RE: Comment Response Letter – Special Use Permit – Discount Tire - Falcon (File #: AL214)

COMMENT RESPONSE LETTER

Site Plan

SITE PLAN
SHEET 2 OF 3

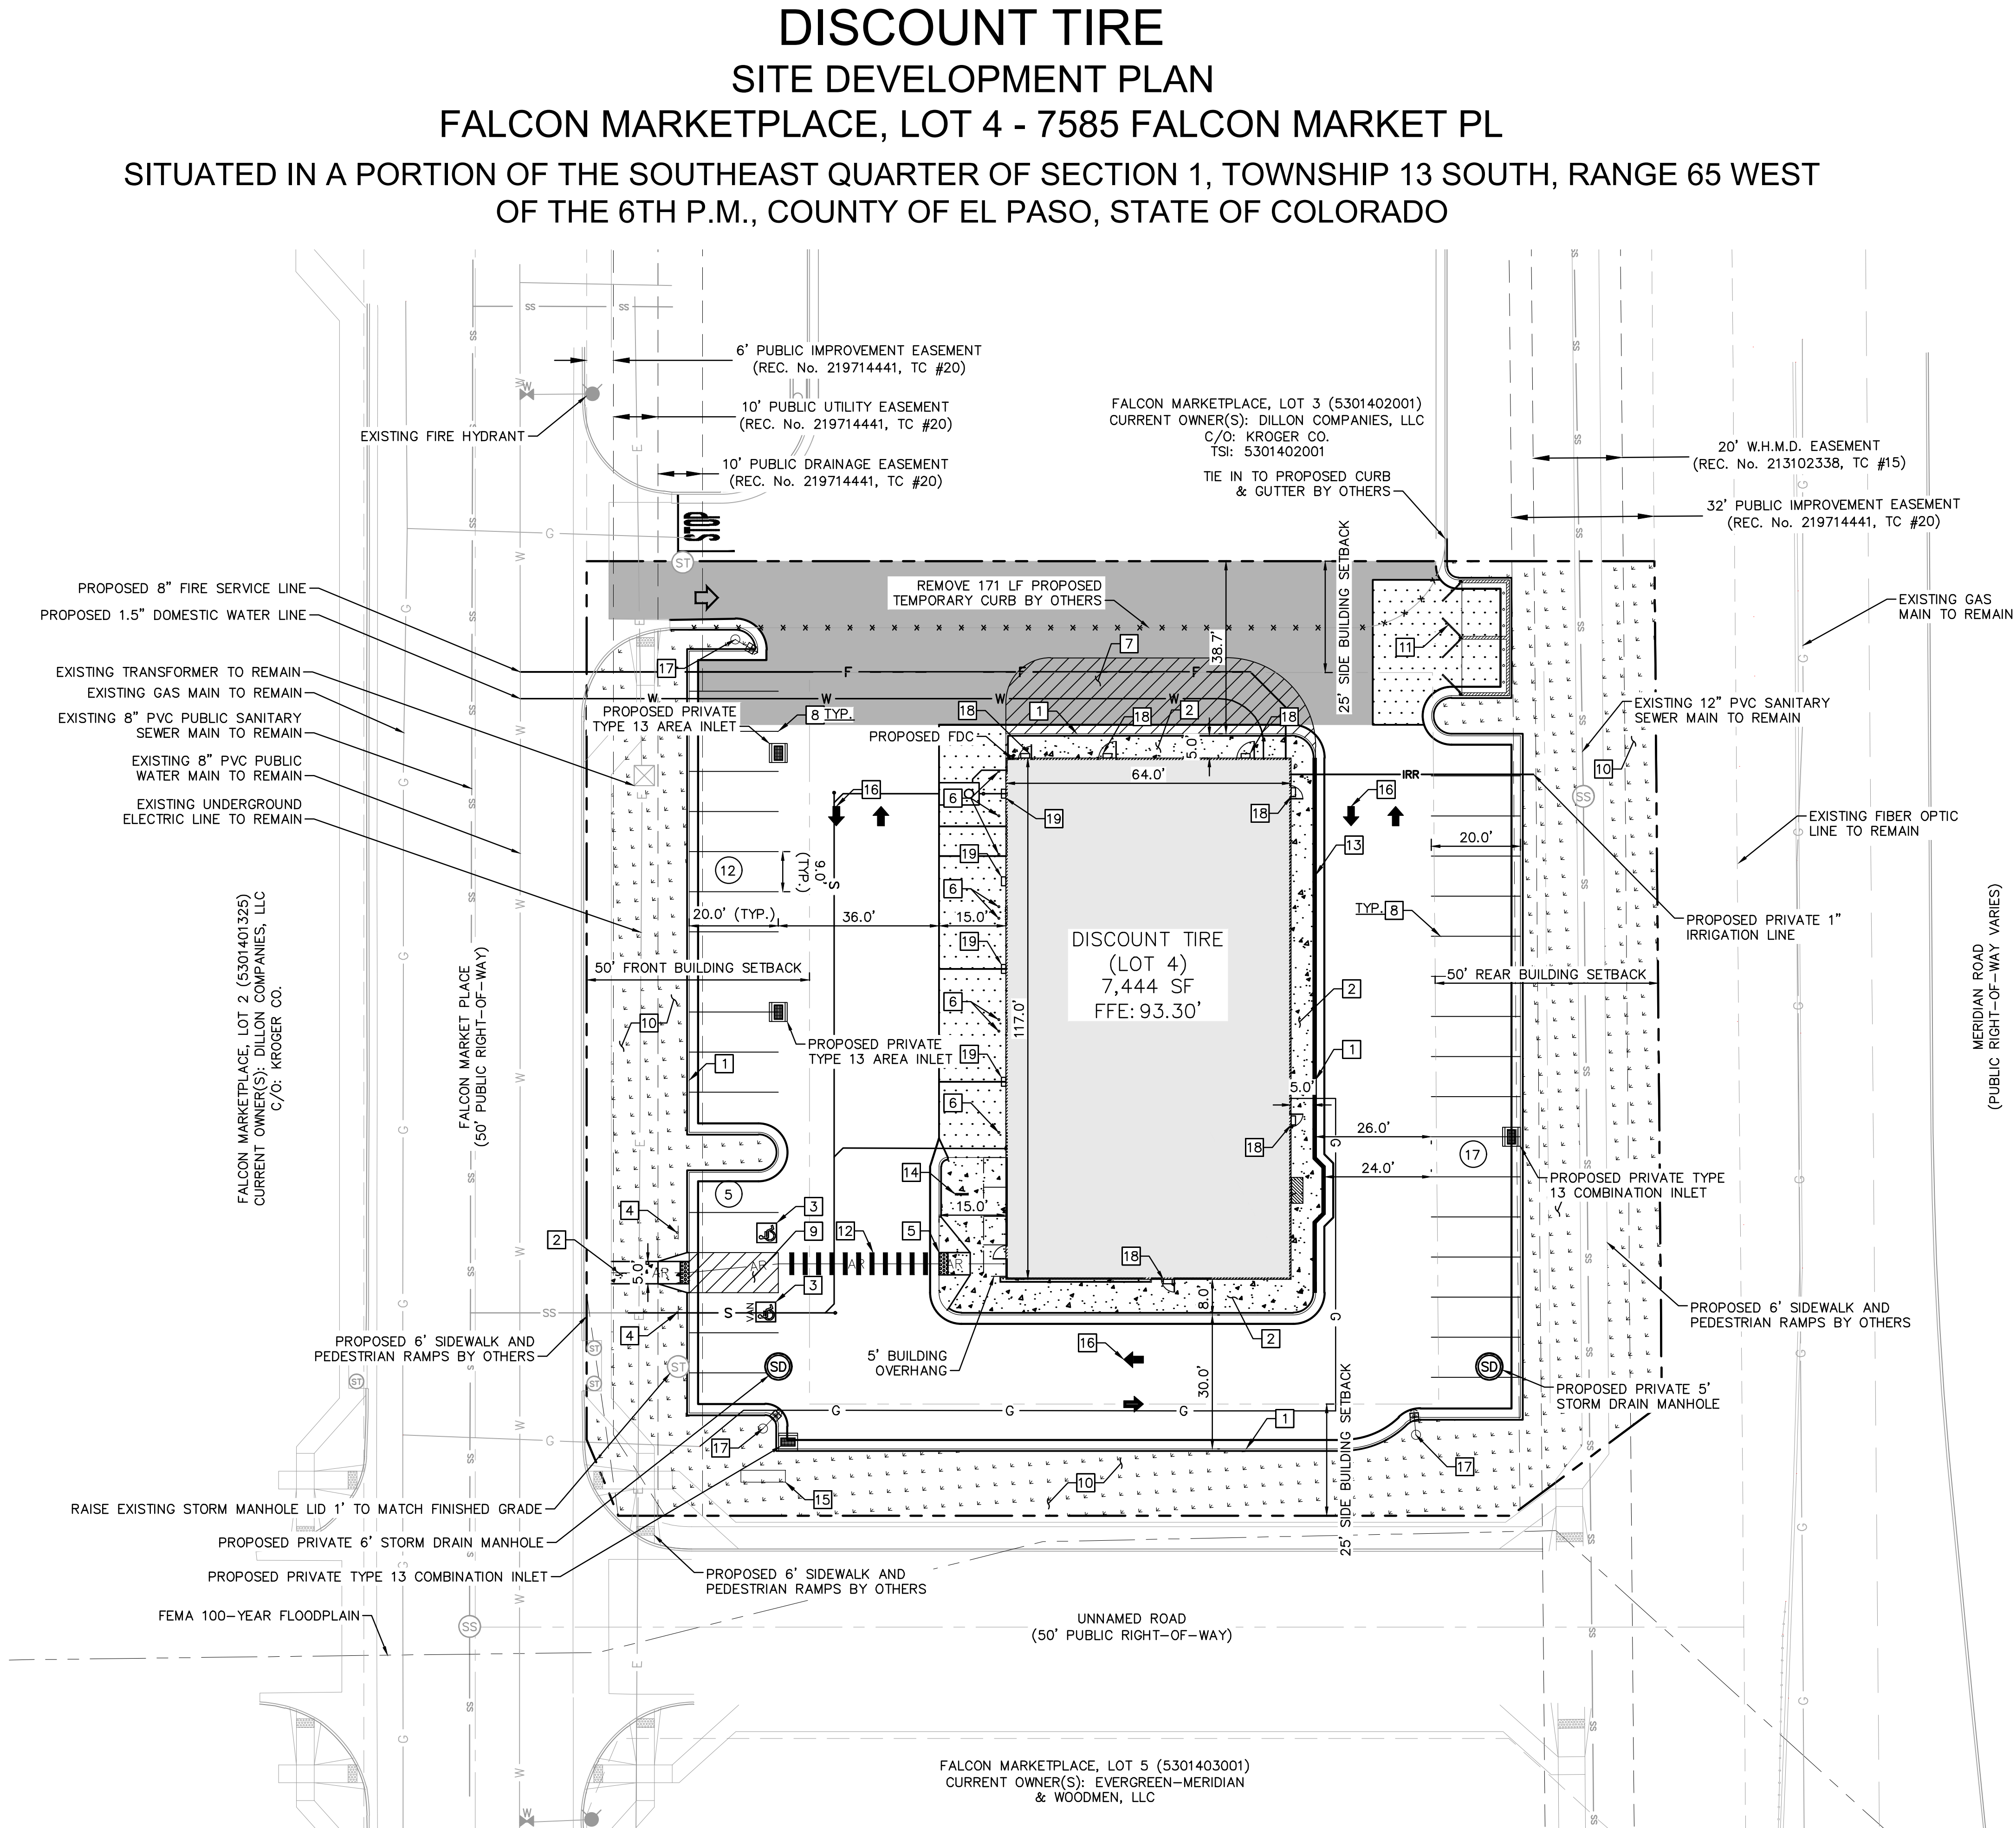
2. Add the following items to the site plan:
 - A. Location, height and intensity of all outdoor illumination
 - B. Location of existing and proposed water and wastewater infrastructure, including well and septic location (if applicable)

- C. Location of all no-build areas, floodplain, drainage facilities
 - *Response: A) The 3 area site lights have been identified with keynote 17. The two different building mounted lights types have also been identified with keynotes 18 and 19. B) All proposed and existing water and wastewater infrastructure was previously shown but have now been labeled. C) The floodplain was previously called out, it extends south of the site in the public roadway. There are no "No-build" areas located on site. The 4 storm drain inlets and 2 manholes have been labeled.*
